**WEST SUSSEX COUNTY COUNCIL
STRATEGIC PLANNING CONSULTATION**

SUBJECT: AW/226/14/HH - New drop kerb & vehicular access

The Twisted Pillar, 127, Aldwick Road, Bognor Regis, West Sussex, PO21 2NY

SITE PLAN : 127 ALDWICK ROAD. BOGNOR REGIS PO21 2NY

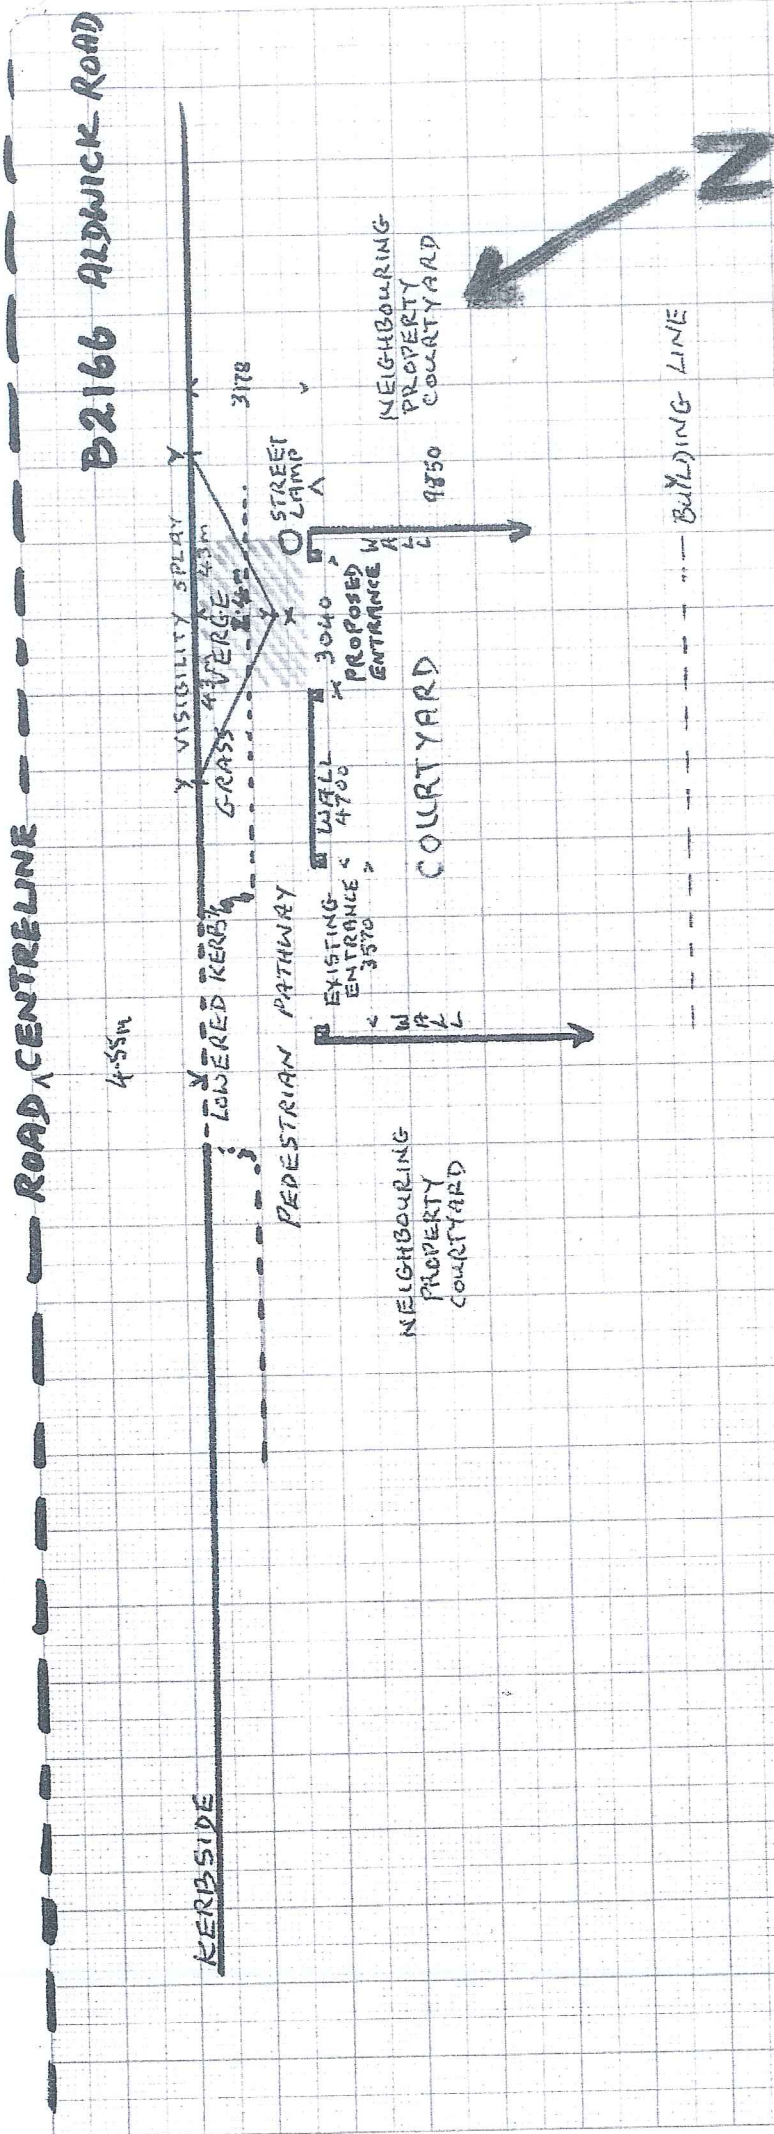
It should be noted that a licence to drop the kerb will should be sought by the applicants to WSCC Area Highways. Whilst this proposal is acceptable in terms of planning, the Area Office may refuse to grant a crossover licence.

The applicant is advised to contact the West Sussex Area Highways Officer covering the respective area (01243 642105) to obtain formal approval from the highway authority to carry out the site access works on the public highway.

127 ALDWICK ROAD VISIBILITY SPLAY

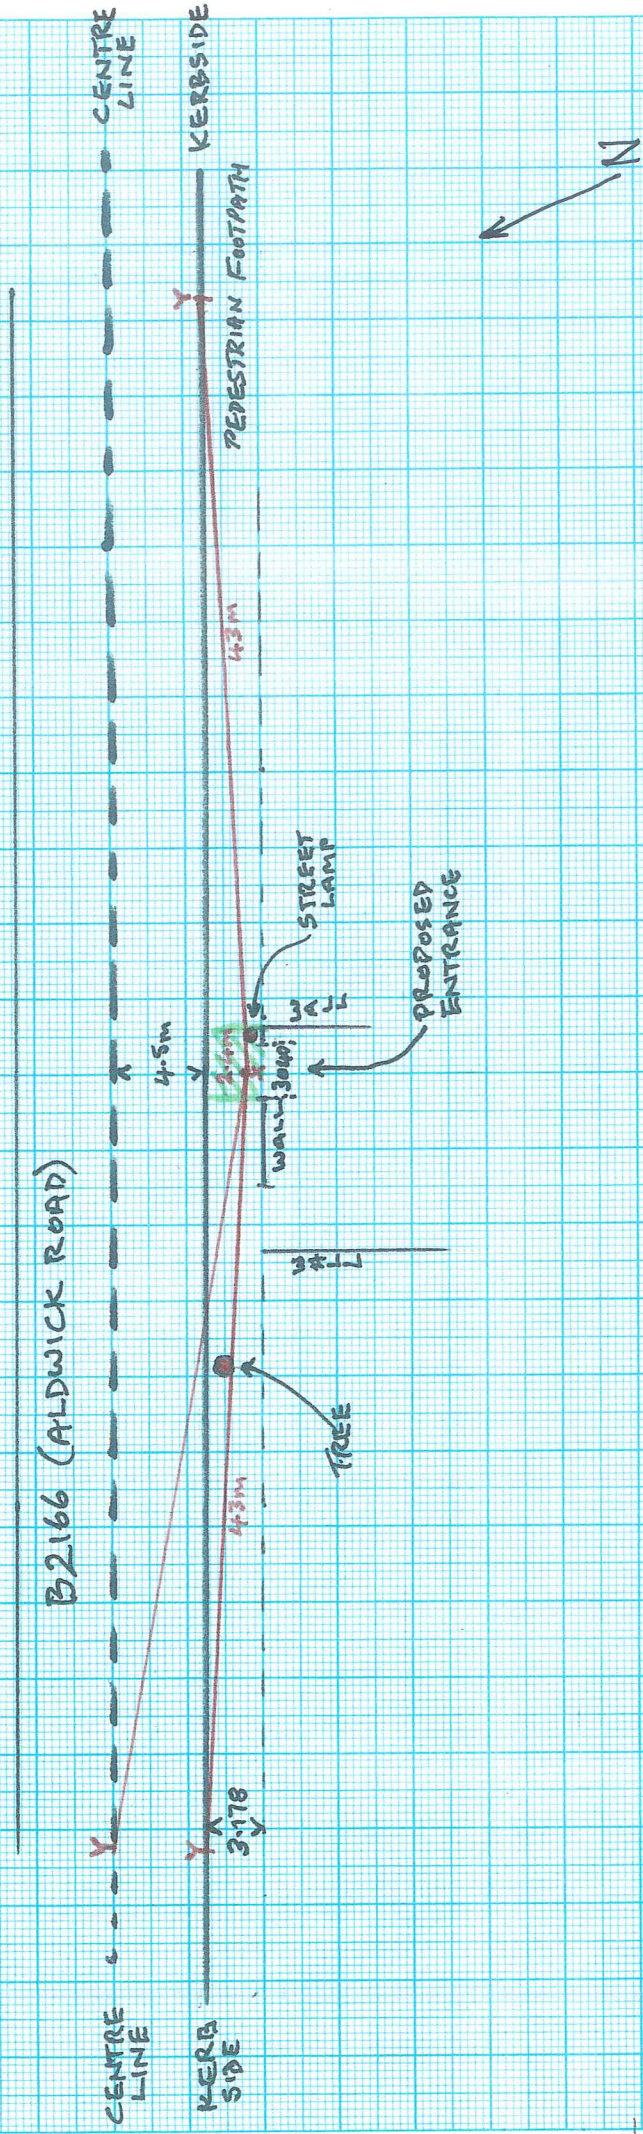
The proposal is for a new access onto Aldwick Road. From an inspection of the plans alone, there is no apparent visibility issue at the point of access onto Aldwick Road. The application is part retrospective in that works commenced in Summer 2014. There are a number of similar "in-out" accesses nearby. From records immediately available to the Highway Authority only the access at 131 Aldwick Road has planning permission from 2002. There were no objections from the Highway Authority to this application. It is generally the Highway Authority's policy to not accept "in-out" accesses due to issues with internal movements, however with nearby properties operating with no recorded issues, the fact that Aldwick Road has a significant bus route, with local pinch points preventing vehicular traffic from flowing at its best rate creates a push factor in moving vehicles from on-street parking to off-street.
